Relevant Representation (Objection) on behalf of Albanwise Synergy Limited (“ASL”) regarding:

Proposed Dogger Bank South Offshore Wind Farms (the “Projects”)

Proposed Dogger Bank South Offshore Wind Farms Order (the “Order”)

With reference to drawing ED13554-GE-1060, 'Works Plan (Onshore)' (pages 18 and 19) (Application Reference 2.6), and the Design and Access Statement Volume 8 (Application

DRAWING NUMBER: ED13554-GE-1060 **PAGE NUMBER:** Page 17 of 19

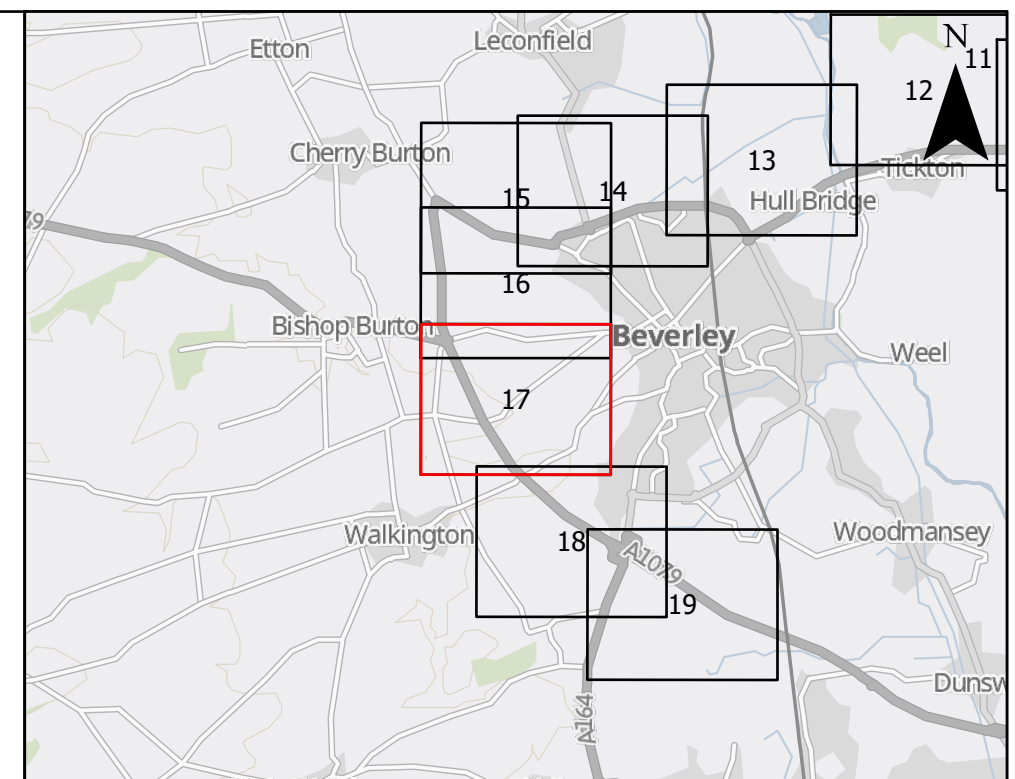
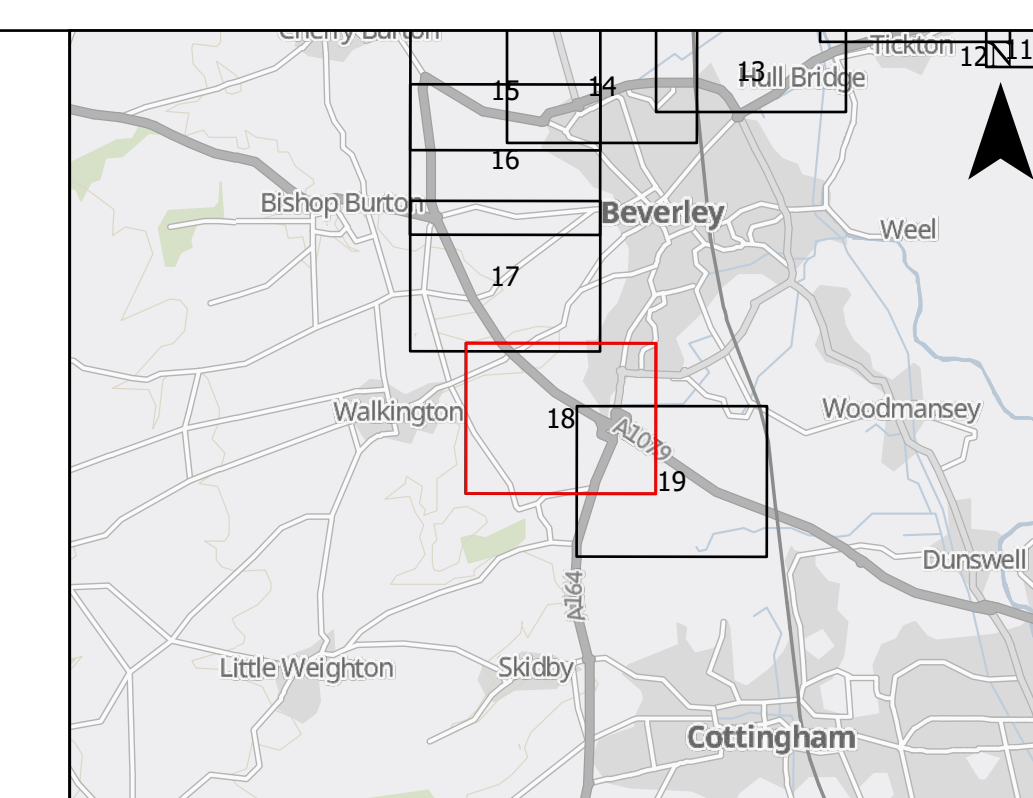
- a. the splitting of the cable route (Works no 32B) across twin paths, involving (but not limited to) land plots 18-054, 18-052, 19-003 and 19-007. Separating the cables by such a distance greatly increases the overall extents of the impact in the land and diminishes the prospects for further utilization of the land for any business interest of AWEL;
